DRB CASE ACTION LOG (SITE PLAN – BUILD P.)

DRB Application No.: 08DRB-70151	Project # 1002270
Project Name: TERRACE ADDITION	
Agent: TOM LUCERO	Phone No.: 843-9283

**City of Albuquerque
Planning Department
Inter-Office Memorandum**

Date: April 1, 2008
To: Jack Cloud, DRB Chair 
From: Carol Toffaleti, Planner, Development Review
Subject: Project #1002270, 07EPC-400179 – The Cube Restaurant

THOMAS LUCERO ARCHITECT
DATE 03-12-08
SHEET NUMBER C-1

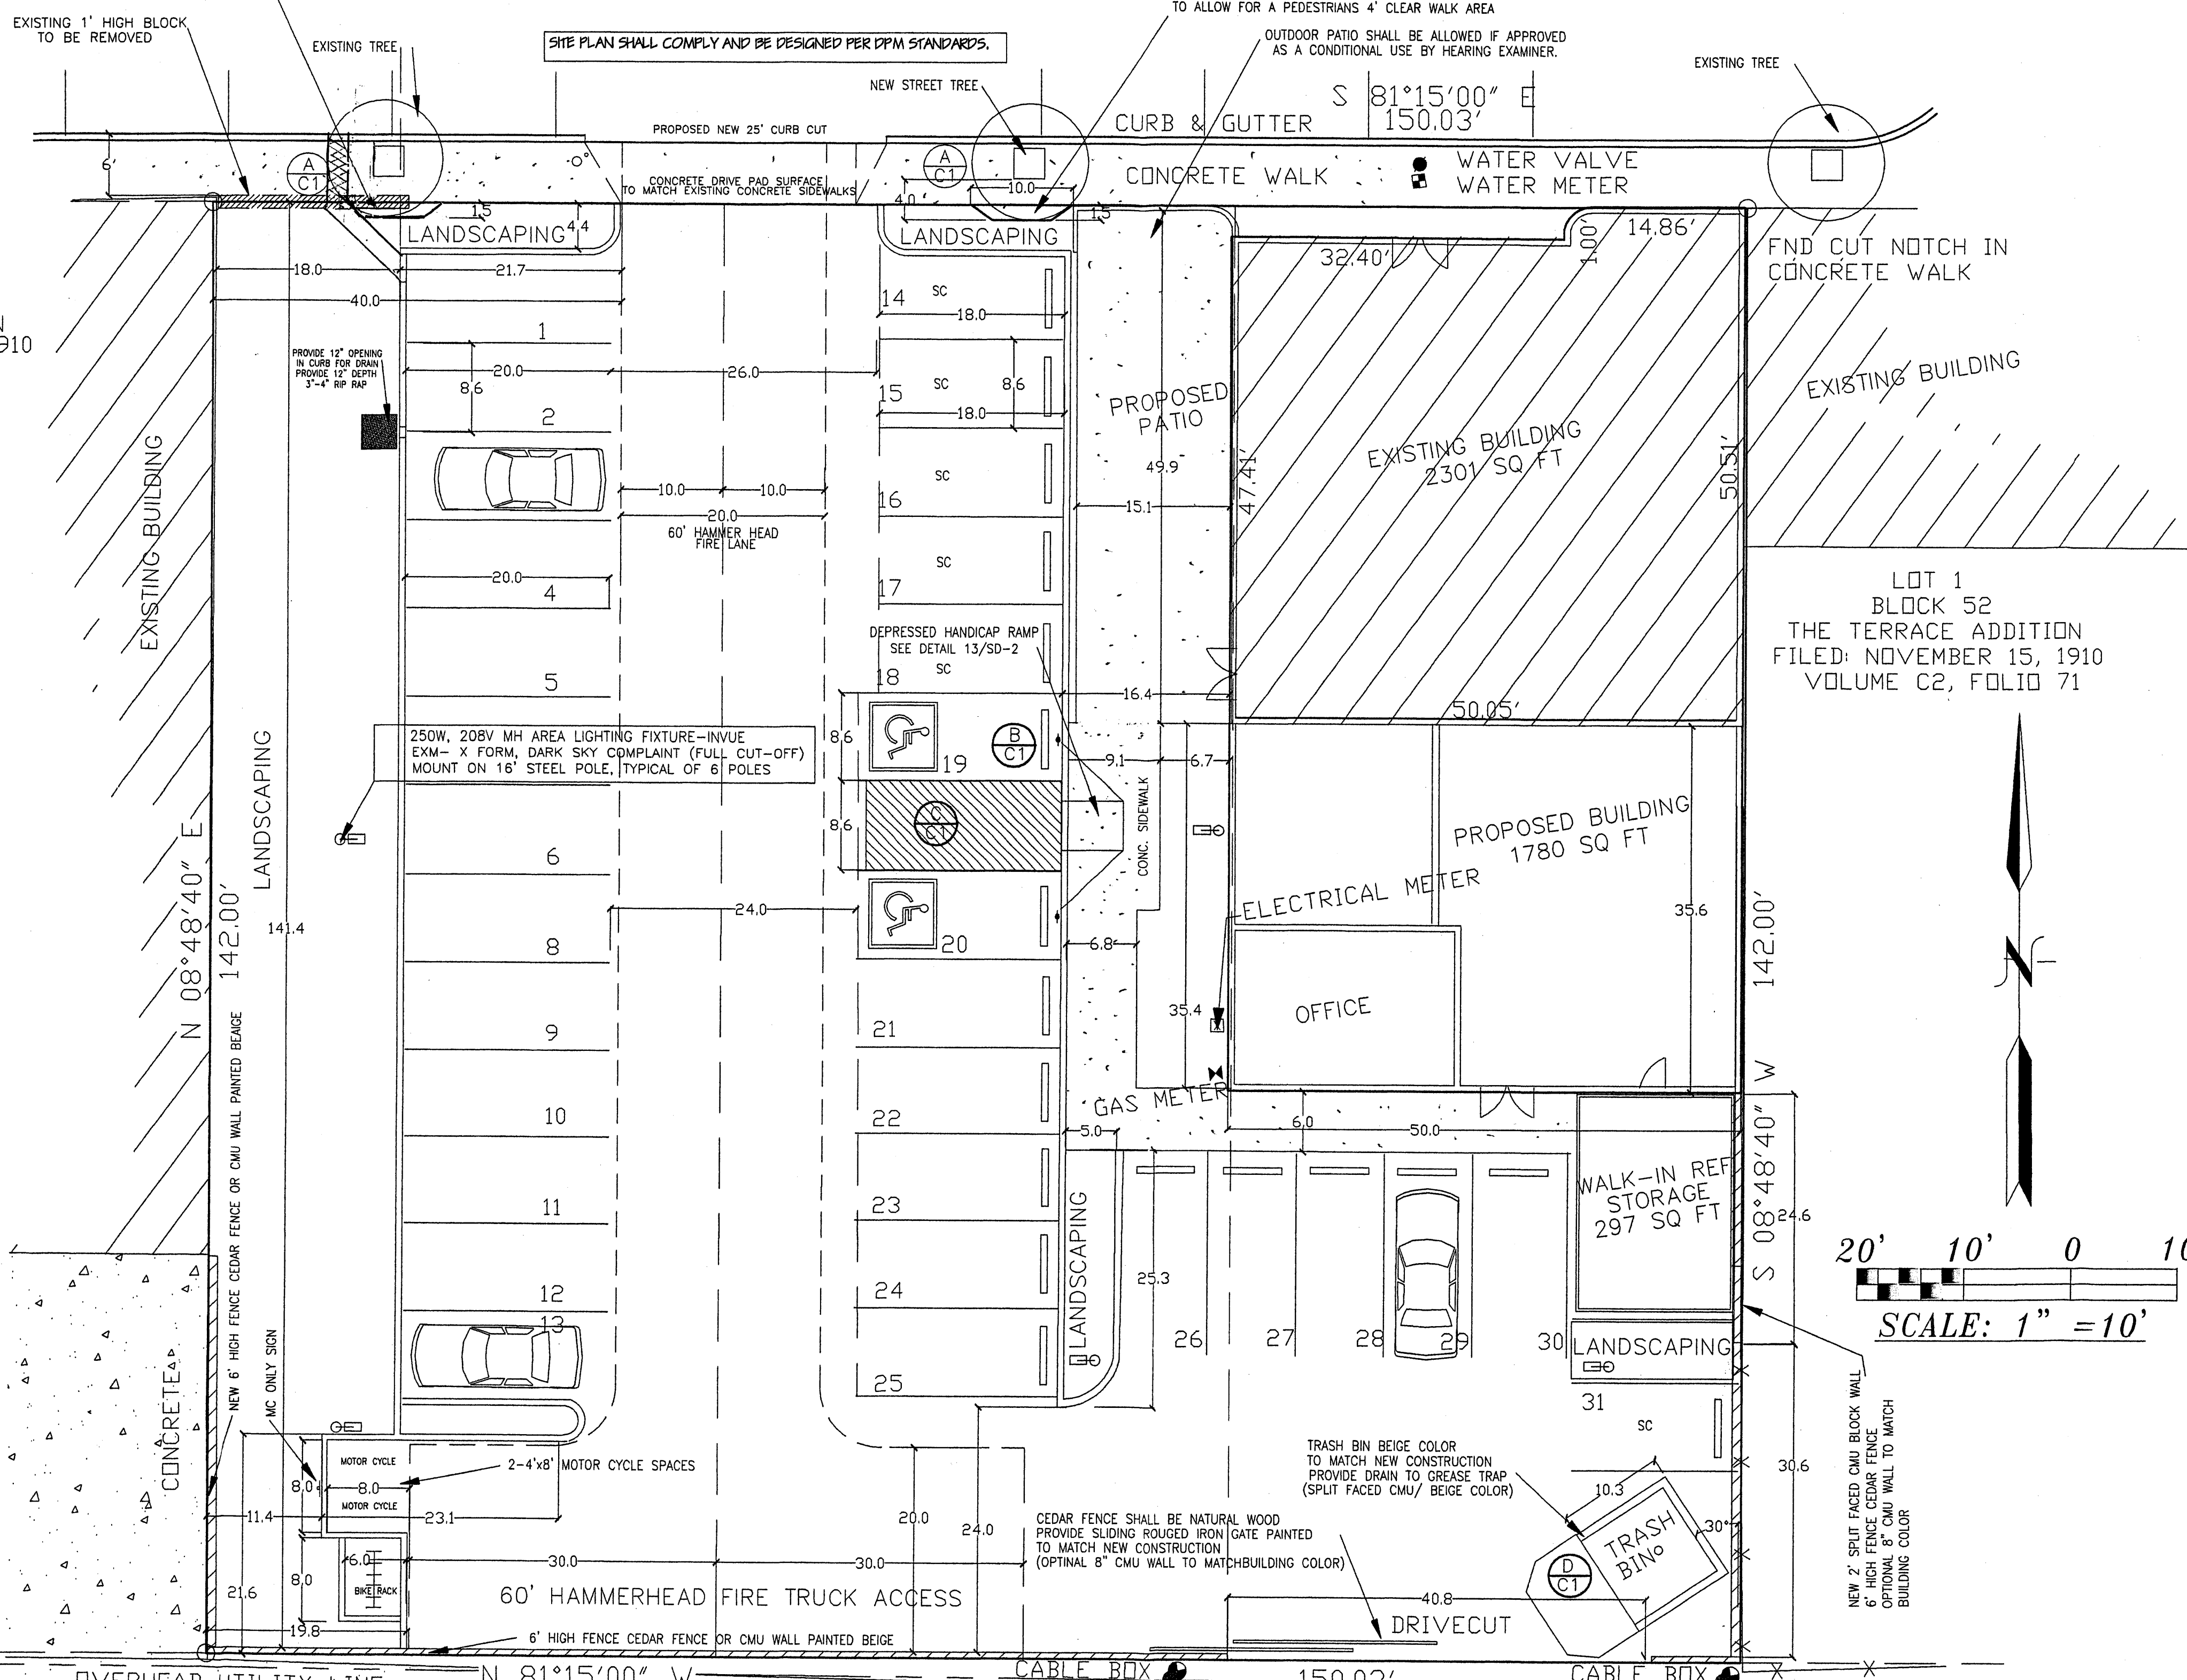
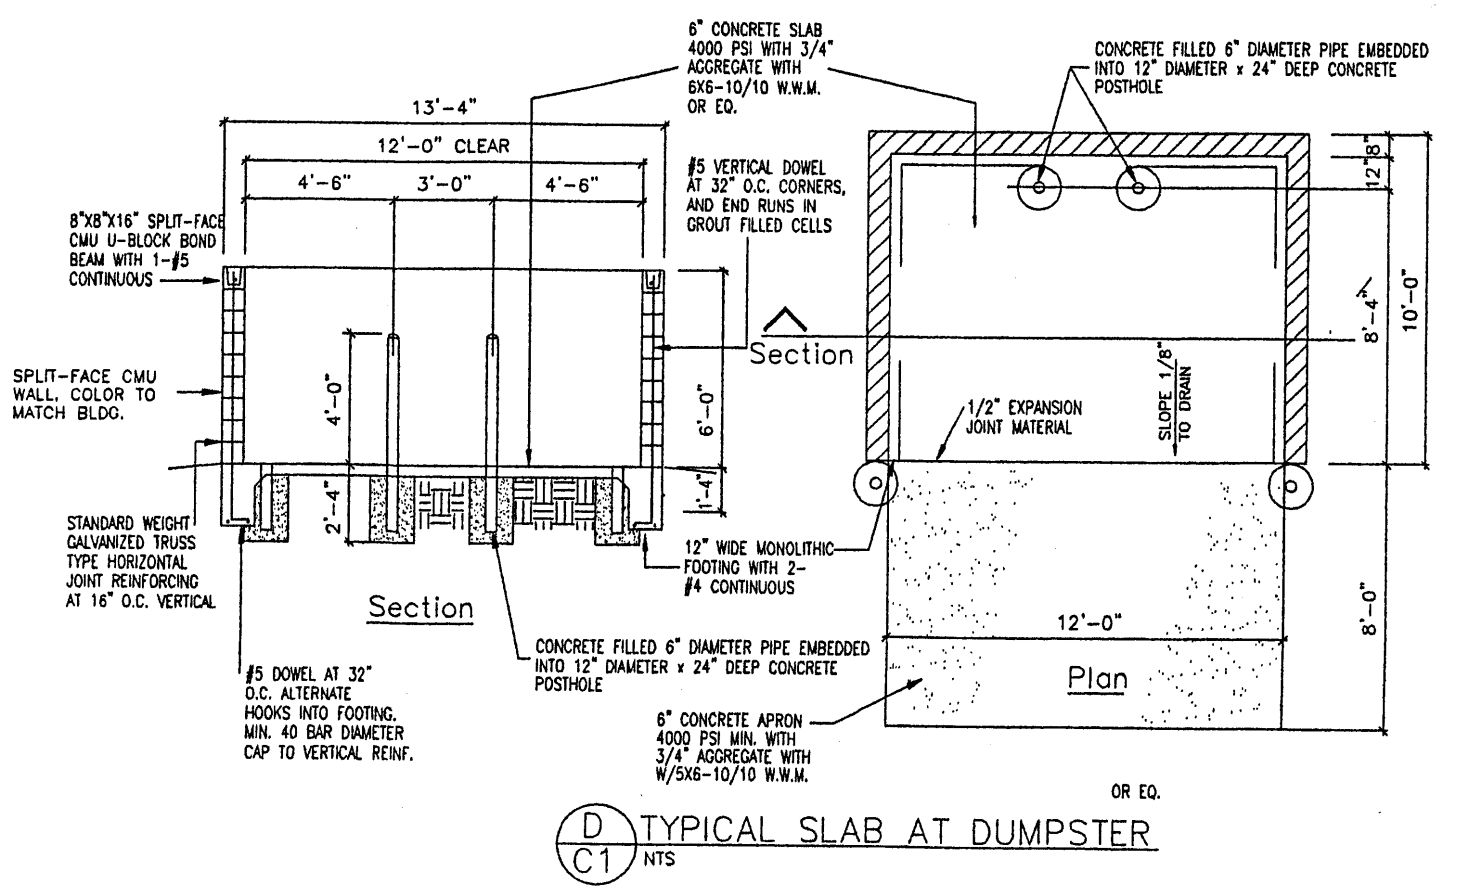
Insert "Zoning" before Hearing Examiner to complete the note (Sheet C-1).

All references to an optional 6' CMU wall shall be deleted (Sheets C-1 and S-1).

The new retaining wall and cedar fence shall be labeled accurately and consistently on all sheets of the submittal (Grading & Drainage, C-1, L-1 and S-1). The retaining wall is split face CMU to match building color.

A wheel stop is needed at the small car space south of the storage unit (C-1).

In addition, staff requests that the required parking spaces be corrected to reflect the accurate occupancy load. The plan approved by the EPC indicated a load of 140 not 149.

THOMAS LUCERO
ARCHITECT
DATE
04-01-08
SHEET NUMBER
L-1

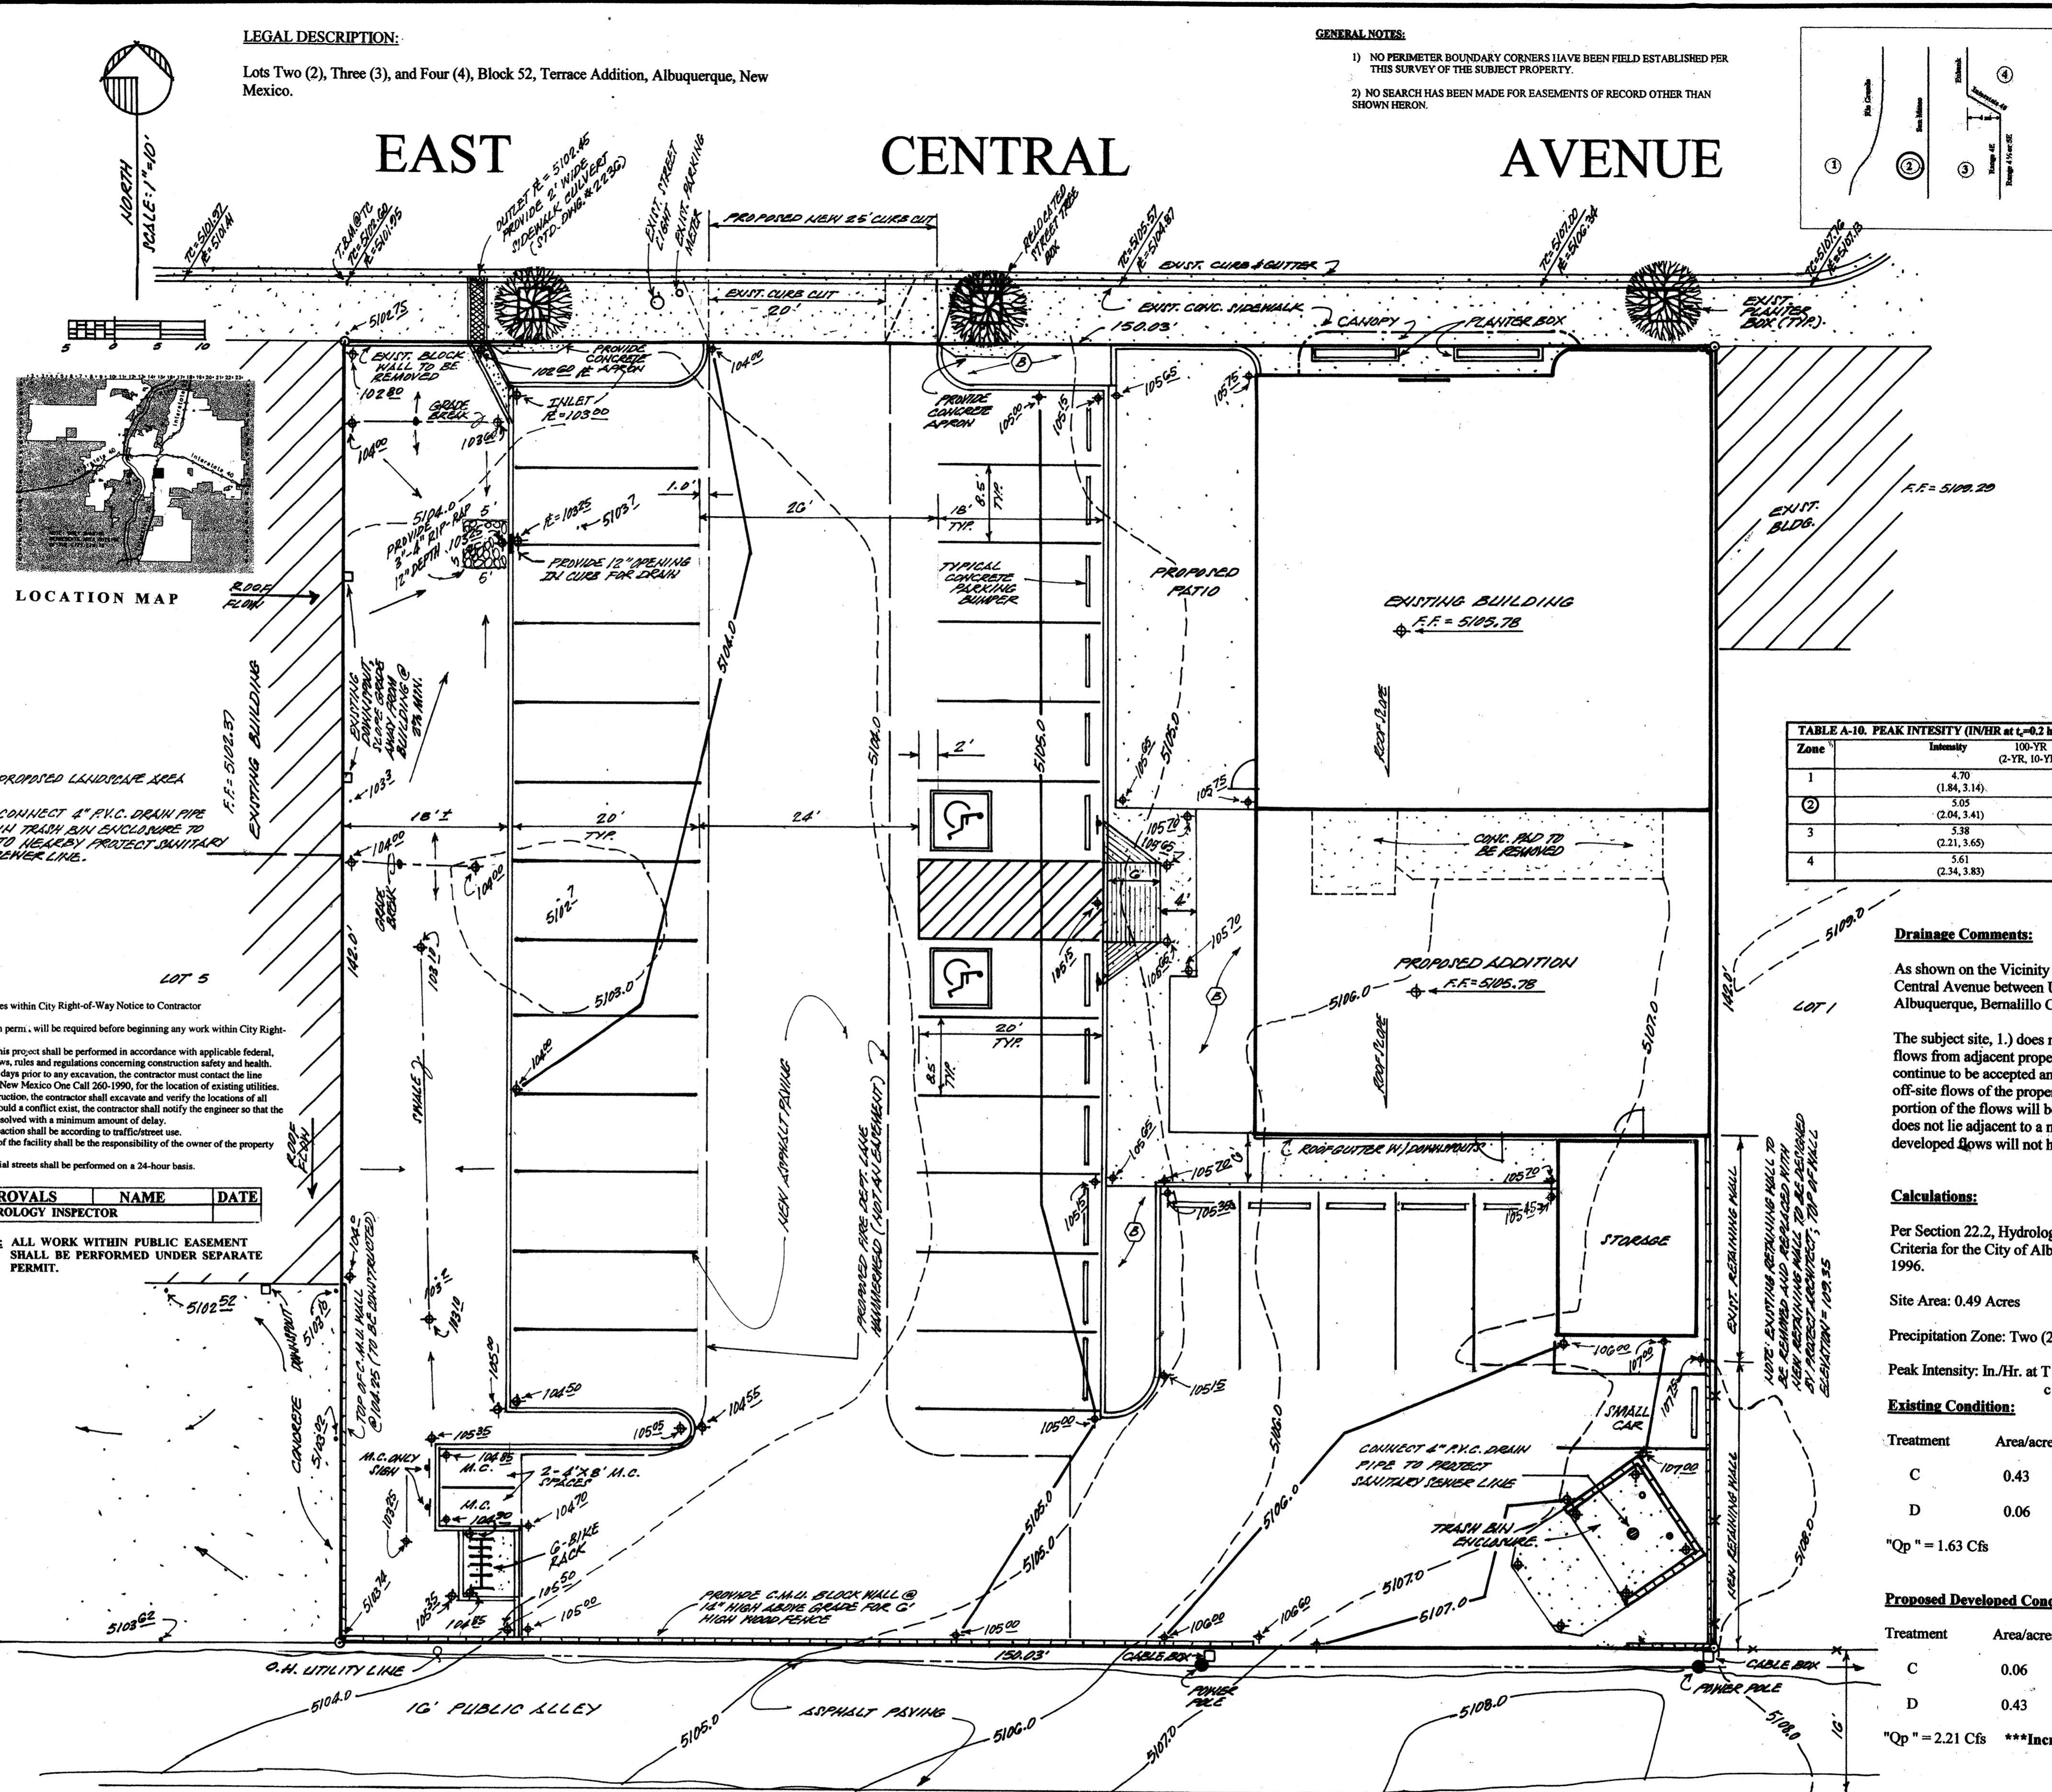
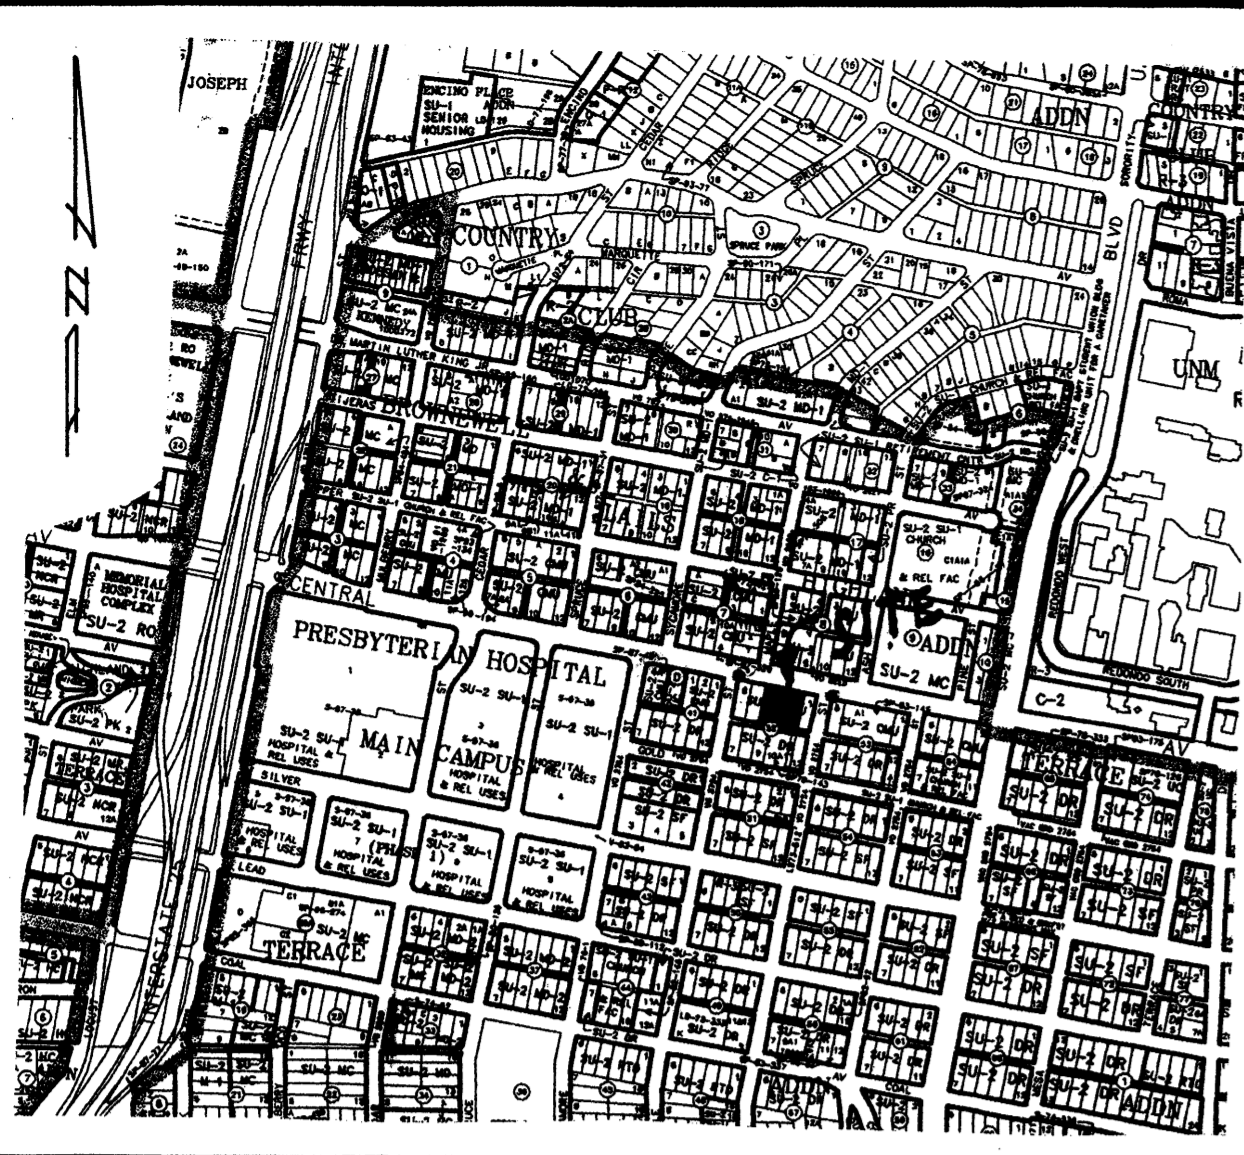
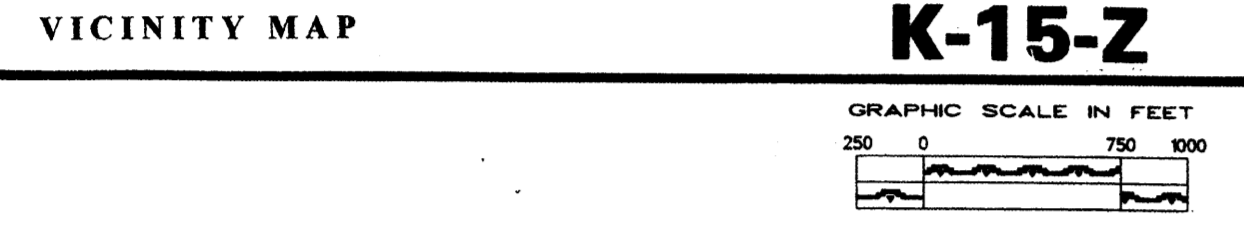
Specify the species, equal or comparable to neighboring street trees along Central Ave.

The size of landscaped beds needs correcting (large west bed and bed adjoining west façade of building), and the rest of the calculations adjusted accordingly.

The number of groundcover plants must be indicated and, together with shrubs and flowering plants, must achieve 75% coverage of total landscaped area provided (at maturity).

In addition, staff requests that the Landscape Note concerning grey gravel be deleted as it is no longer appropriate.
